MEMORANDUM

To: FILE
From: Jean Fraser
Subject: Application ID: 2014-138
Date: 8/25/2014

Comments Submitted by: Marge Schmuckal/Zoning on 7/29/2014

PROJECT: MULTI-USE DEVELOPMENT
2282 CONGRESS ST., PORTLAND, ME
SHEET TITLE: SITE LAYOUT PLAN
CLIENT: CJ DEVELOPERS, INC.
35 PRIMROSE LANE, FREEPORT, MAINE 04032
AND PORTLAND PROPERTY HOLDINGS, LLC
2 MAIN STREET, SUITE 200, TOPSHAM, MAINE 04086

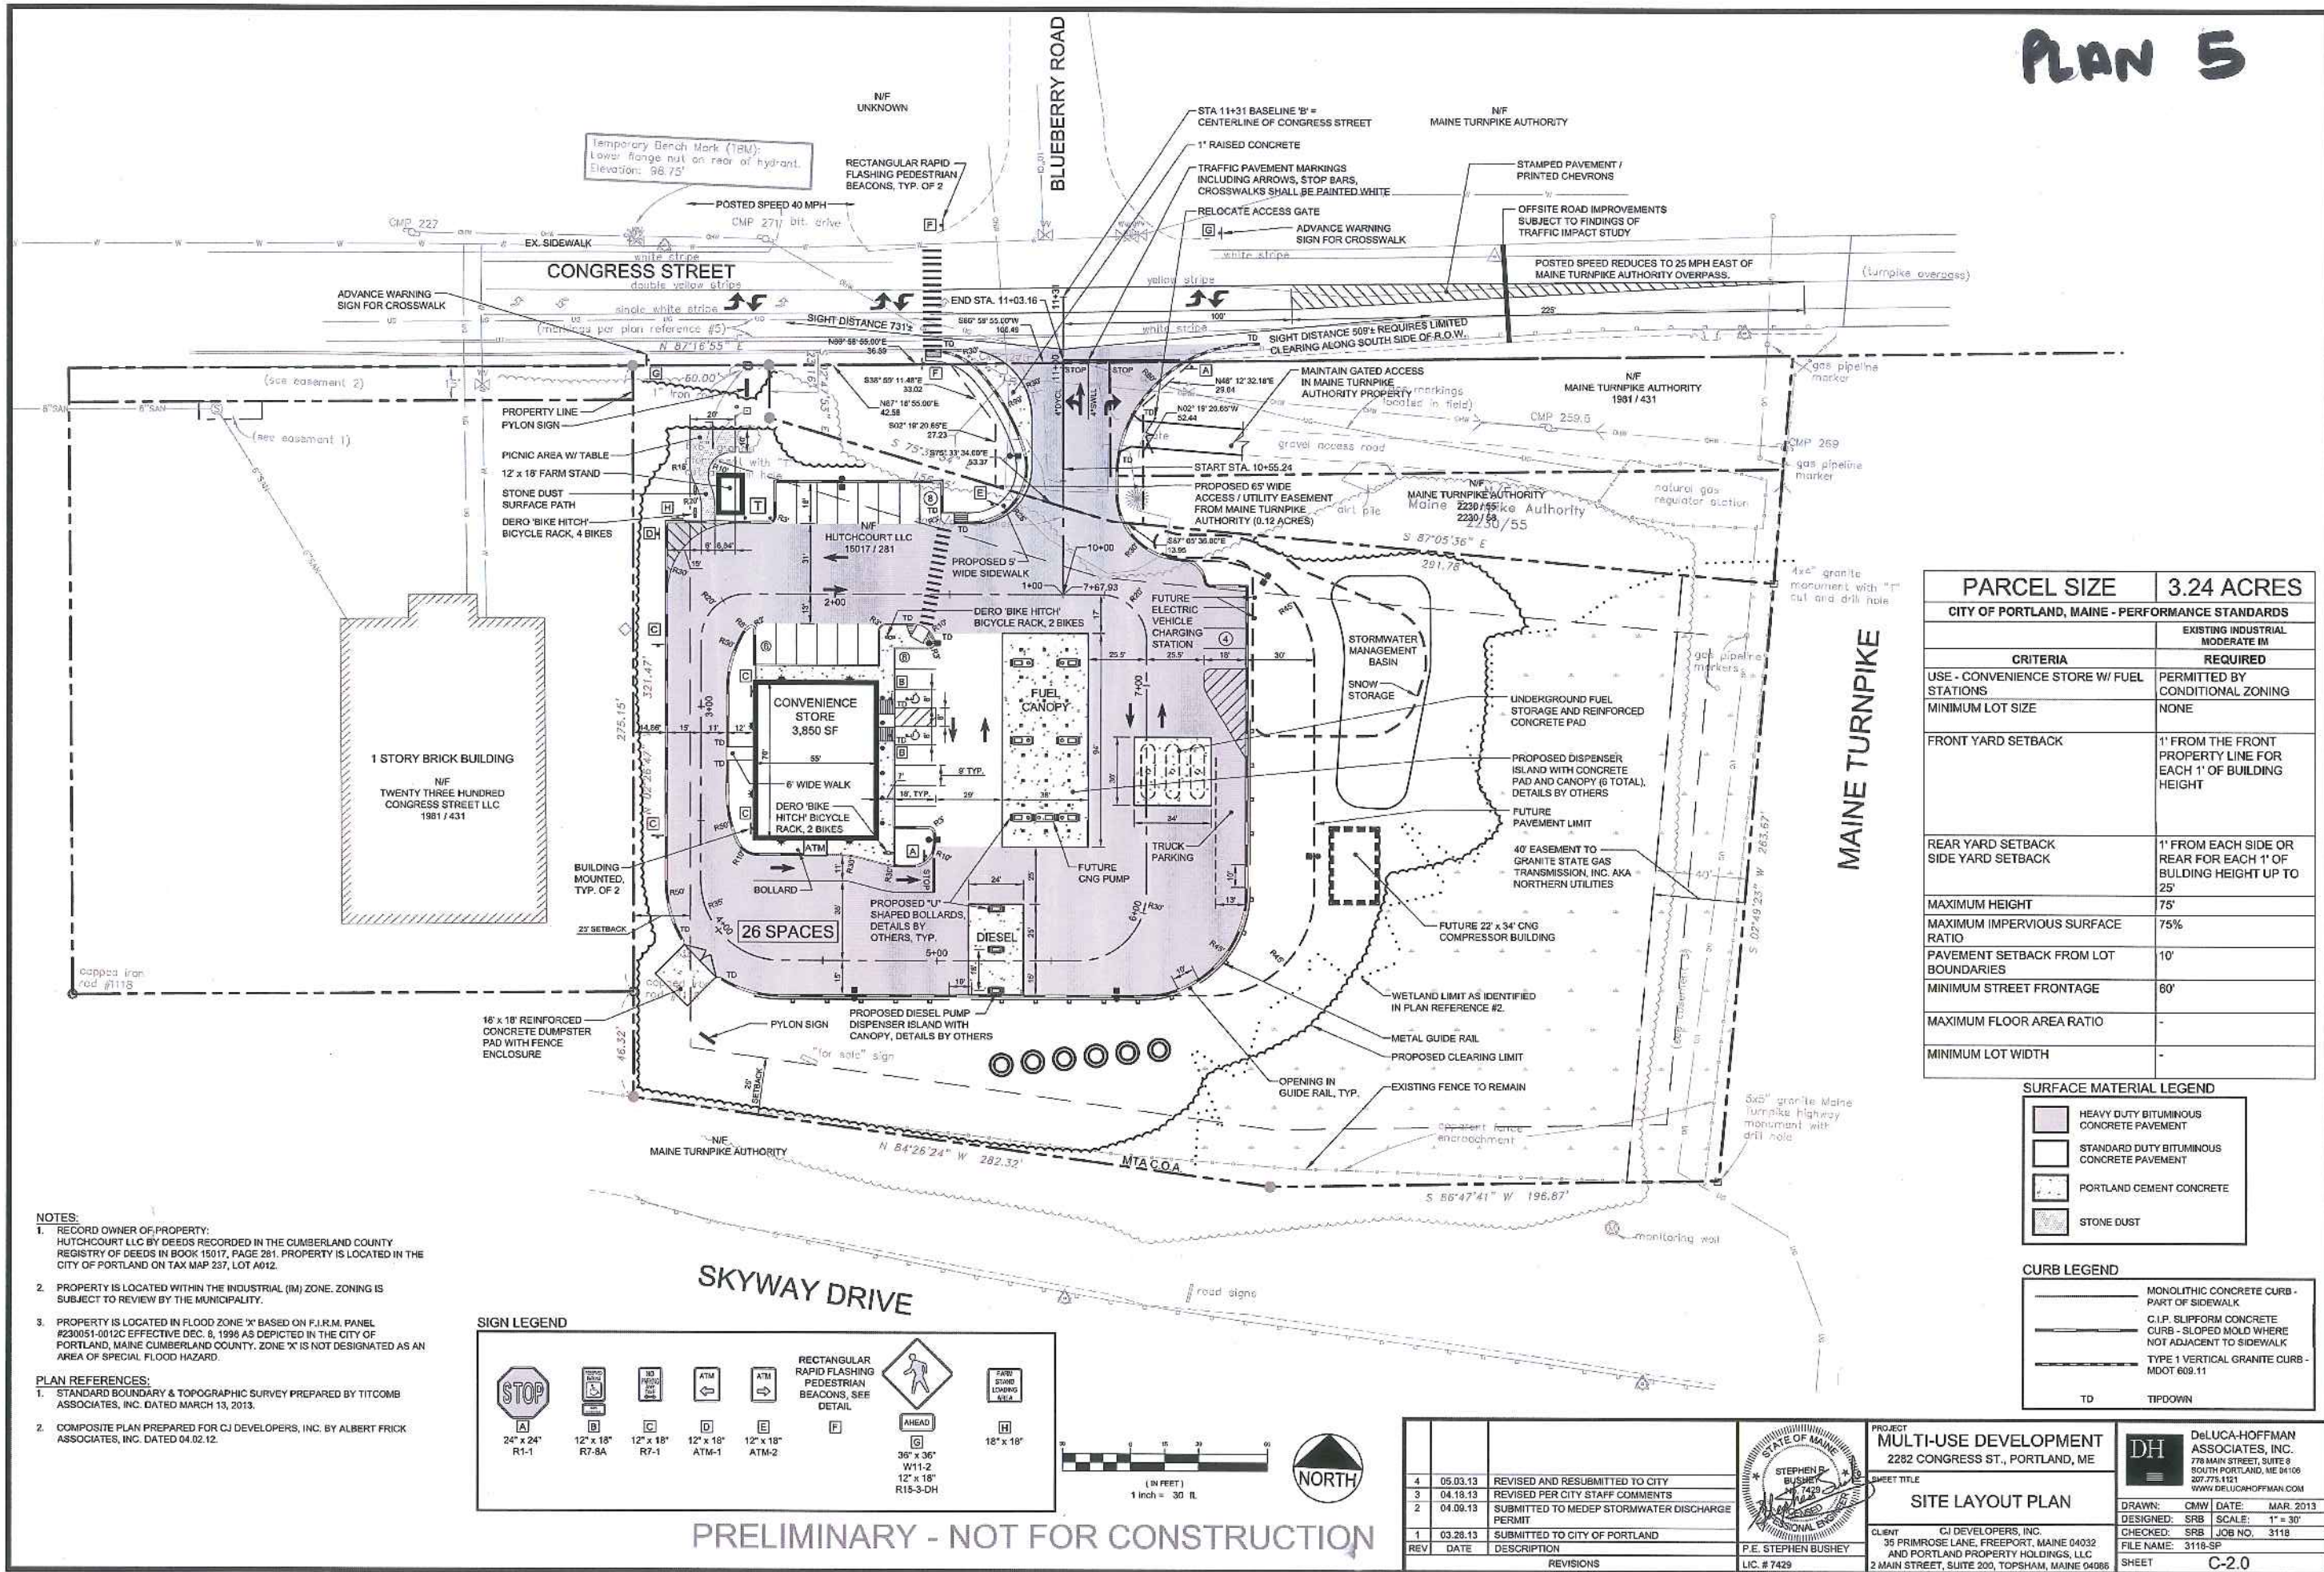
I have reviewed the latest information on the C-59 Conditional / Contract Zone which is a Conditional I-M Zone (allows several specific uses that are shown on the existing site plan. Most of the dimensional requirements are being met. However, there is a 10' pavement set back requirement under section 14-250(h). It is not being met with the 8 parking spaces that are shown closest to the entrance off of Congress Street. That needs to be revised. Also there are no elevations of the building to confirm the maximum height is being met (although I am pretty sure that it should be meeting the maximum). The allowable uses as I read it seem to imply that "Natural gas and electricity fuel shall be included in the fuels that the major auto services station is allowed to sell". I do not see those fuels available on the site plan. I would want the applicant to point out those fuels to me for compliance.
